WEST SUSSEX COUNTY COUNCIL CONSULTATION

TO:	Arun District Council FAO: Simon Davis
FROM:	WSCC - Highways Authority
DATE:	2 November 2021
LOCATION:	78A Langbury Lane Ferring BN12 6QE
SUBJECT:	FG/176/21/PL Extensions to front parking. This site is in CIL Zone 4 (Zero Rated) as other development.
DATE OF SITE VISIT:	n/a
RECOMMENDATION:	Advice
S106 CONTRIBUTION TOTAL:	n/a

REV	DATE	AMENDMENT	BY
PROJECT 78 LANGBURY LANE FERRING, WORTHING SUSSEX. BN12 6QE			
DRAWING EXISTING and PROPOSED SITE PLAN			
Date Sept 2021	Drawn By PJC		
Scale 1: 200 @A3	Iss. App. By DKC		
Drawing No 201	File Location 0247

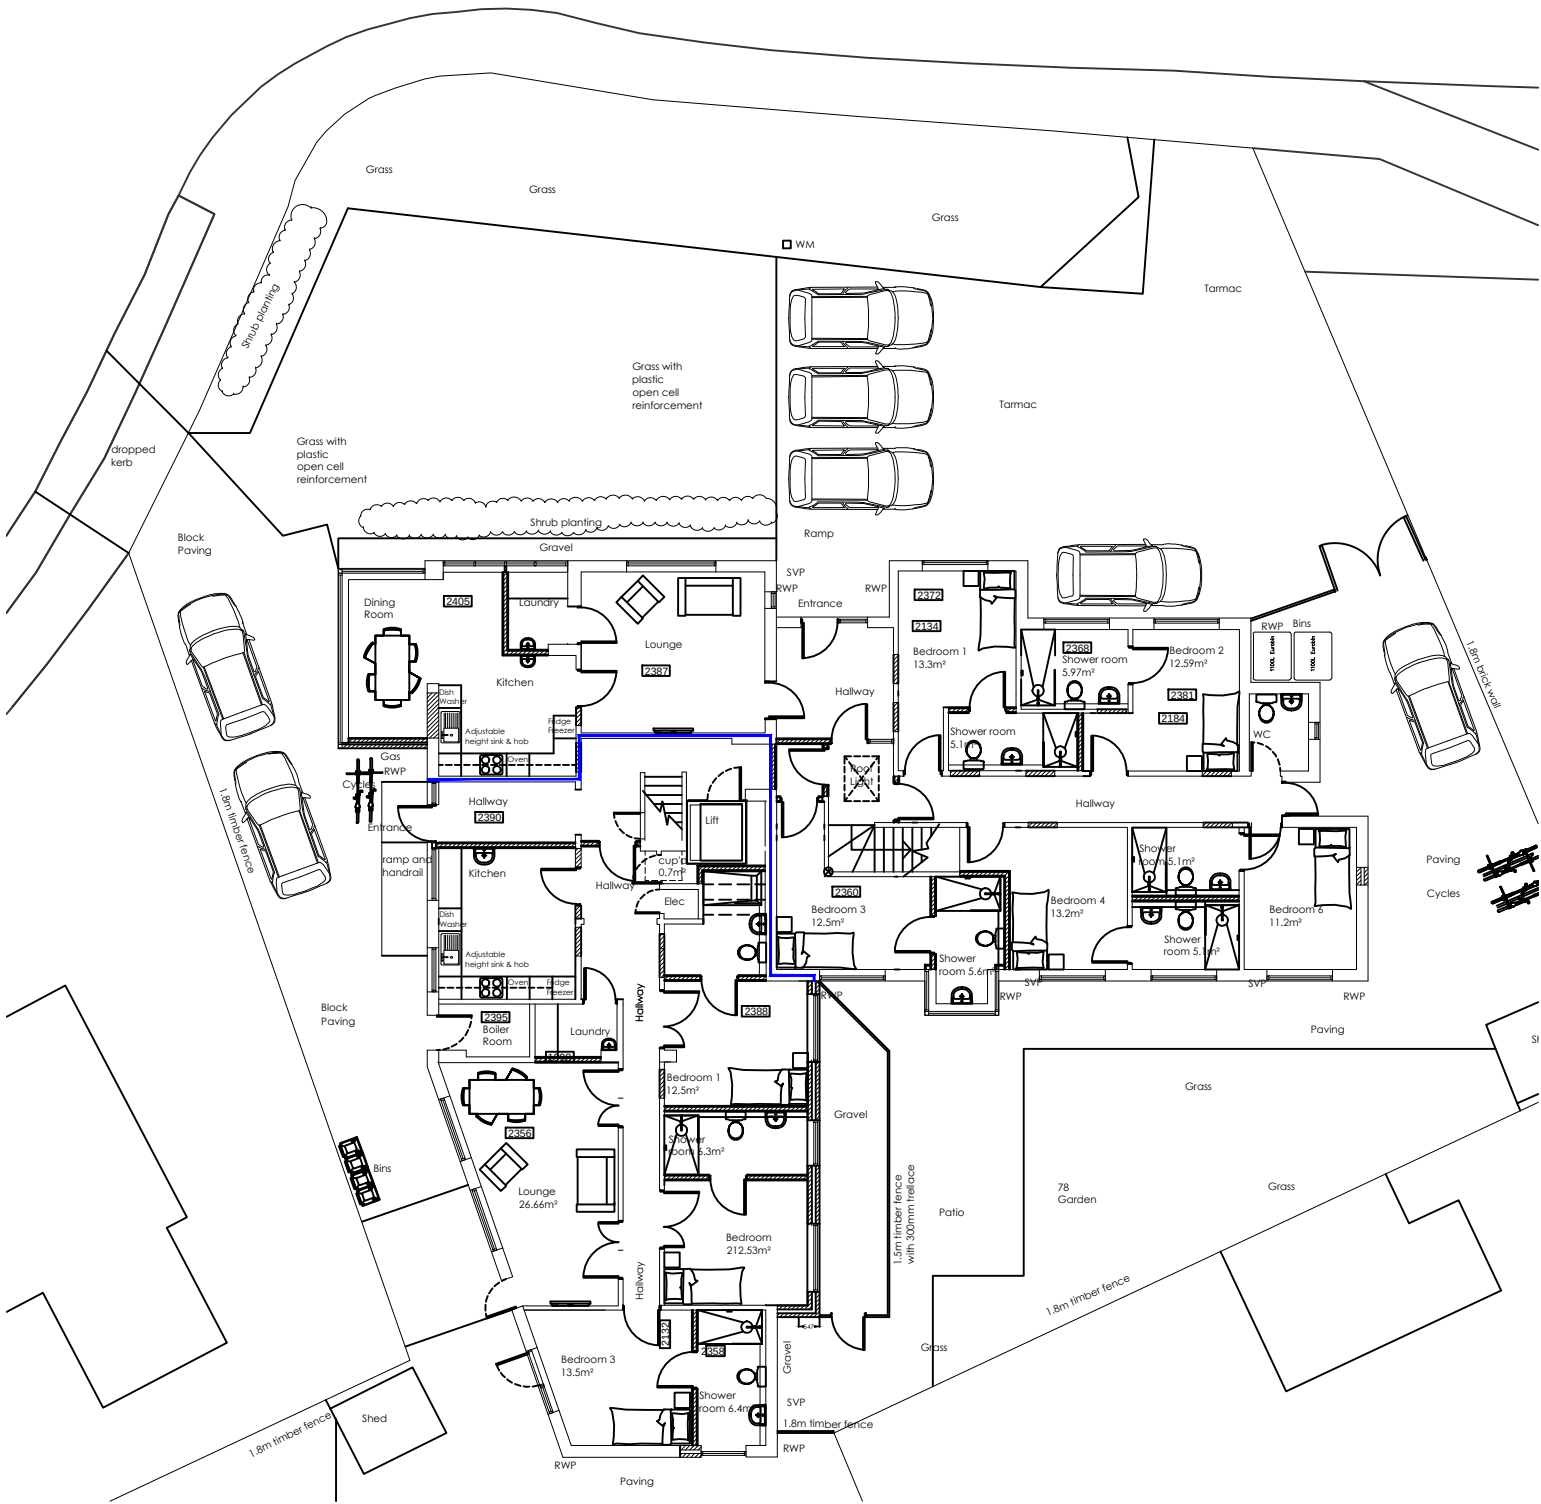
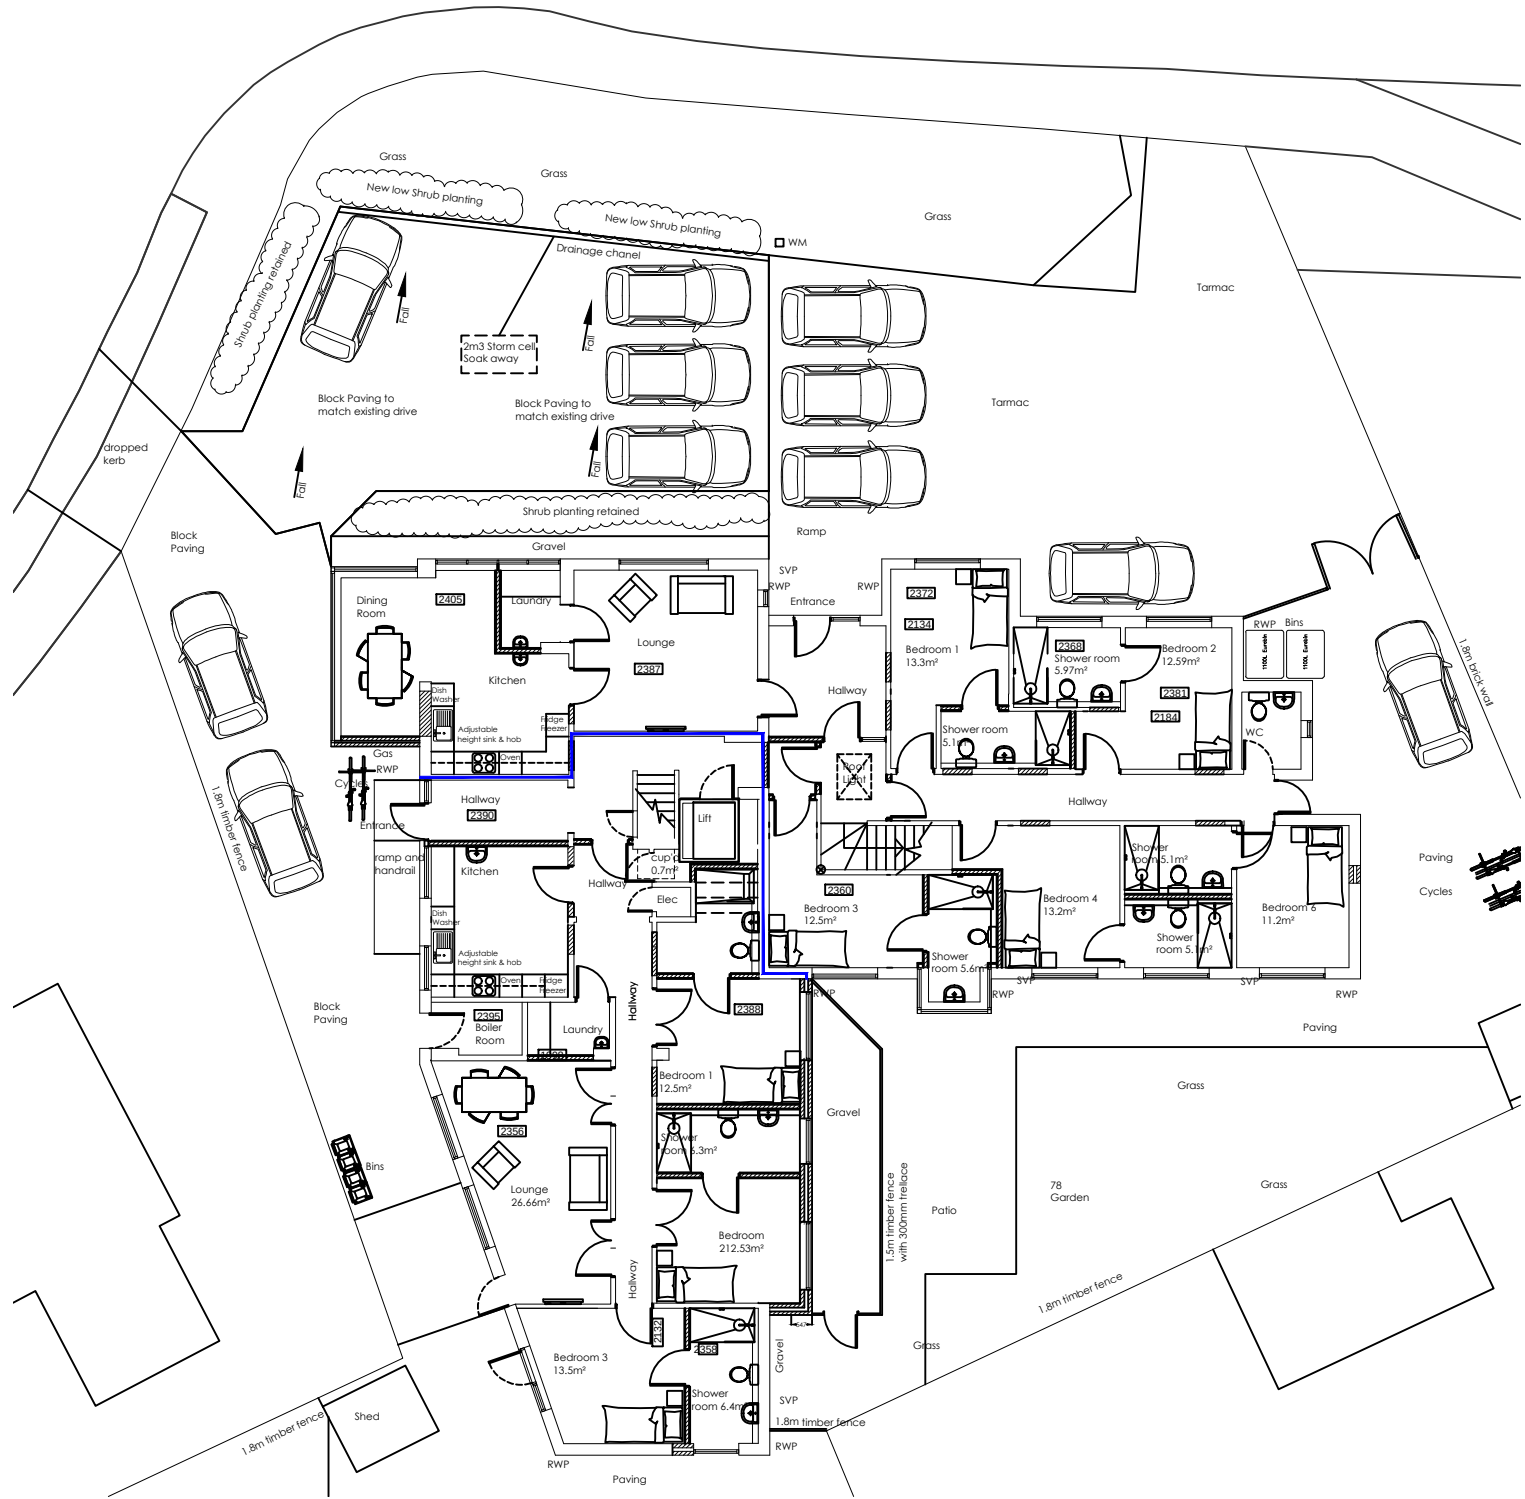
The proposed site plans demonstrates four parking spaces on the site frontage. These spaces do not meet minimum specifications of 2.4 x 4.8m as set out in Manual for Streets (MfS), however there appears to be sufficient space on site for a total of 4 vehicles to park in an informal arrangement. A turn on site would be preferred however this may not be possible due to site constraints if the parking area was full. The LHA would not raise a highway safety concern to this arrangement given the local highway context and that neighbouring properties operate similar arrangements without evidence of highway safety concern.

No part of the development shall be first occupied until the car parking has been constructed in accordance with the approved site plan. These spaces shall thereafter be retained at all times for their designated purpose.
